From:
To: [DCAdmin](#)
Subject: REP Planning application 2023/91212
Date: 05 June 2023 07:49:19

From:
Sent: Saturday, June 3, 2023 10:51 AM
To: Ellie Worth <Ellie.Worth@kirklees.gov.uk>
Subject: Planning application 2023/91212

Bankfield Drive, Holmbridge

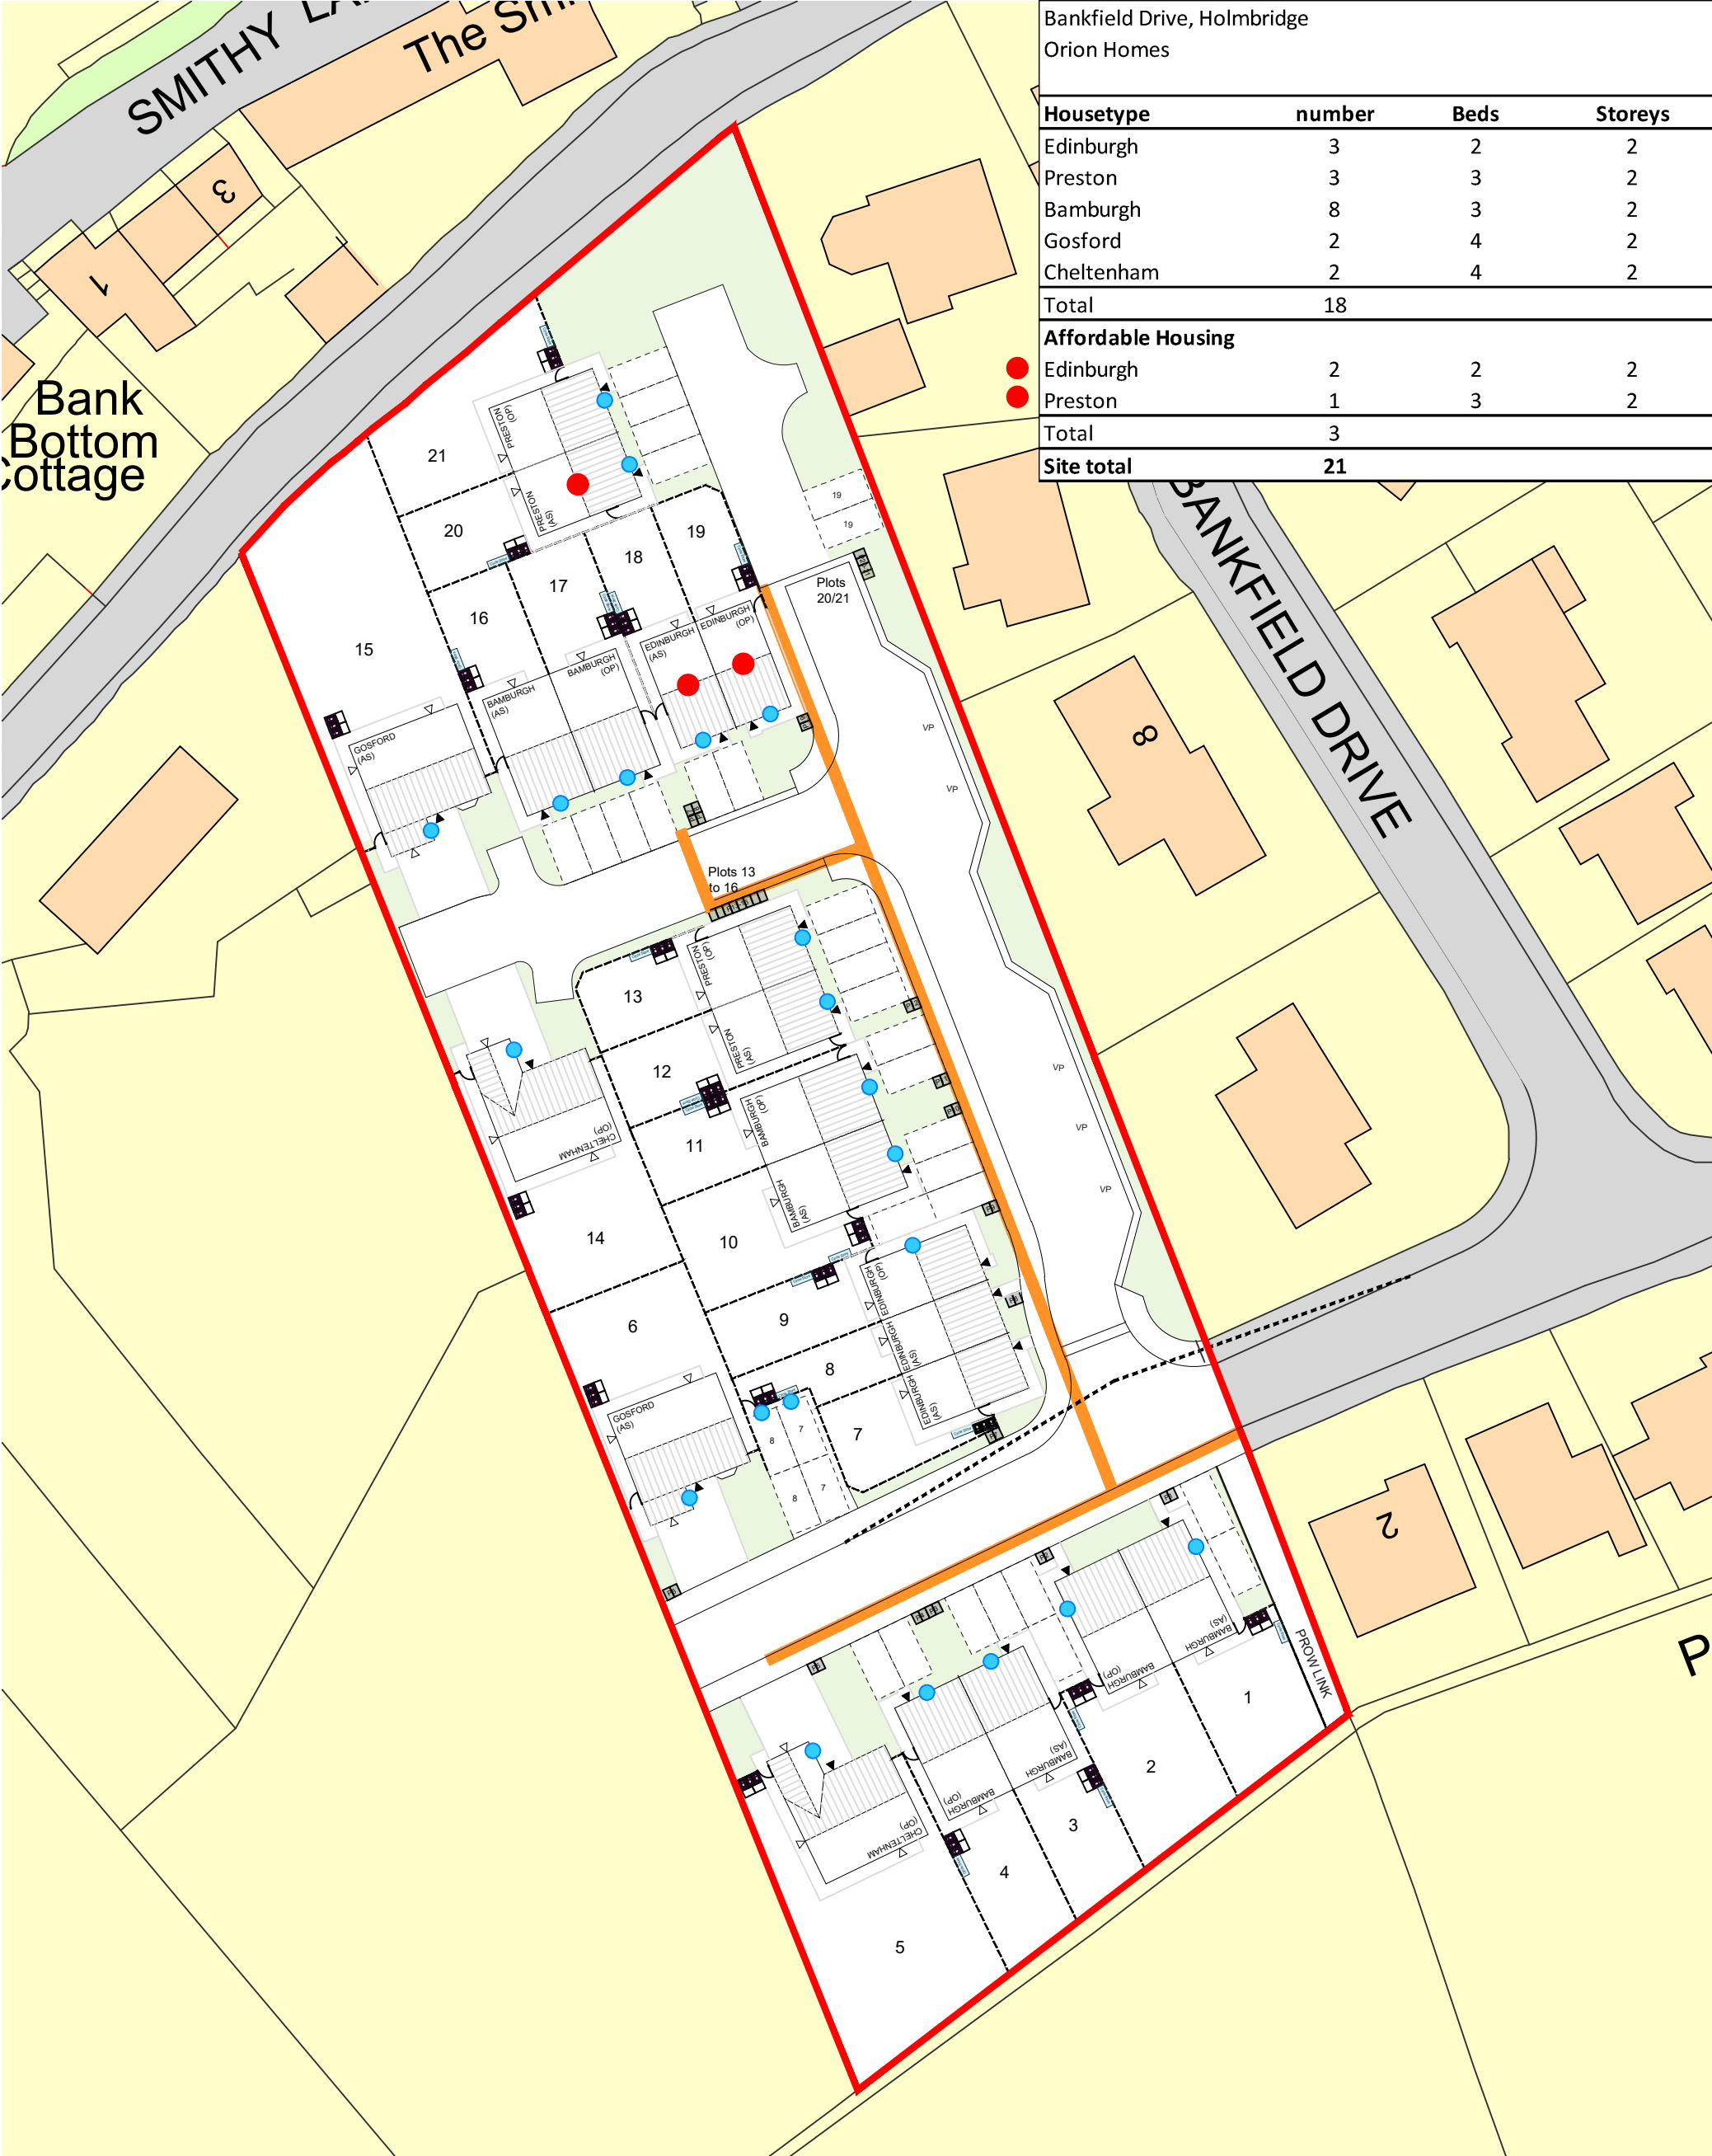
I am writing with regard to the above planning application. The planning application does not contain any cross-sectional plans or mention of how the steep gradient of the site will be built into. This could have a significant effect on the light into existing properties. The distance of only 12 metres from the existing properties on Bankfield Drive is unacceptable. In particular, plot 16 is only 12 metres from 10 Bankfield Drive. Whilst I appreciate that this is the minimum distance recommended by Kirklees, the existing property will be completely overshadowed and there will be significant loss of light from the habitable rooms and principal garden, particularly in winter months. I therefore request that a longer distance is enforced (minimum 15 metres), this would also be more in line with the layout of the existing estate along Bankfield Drive.
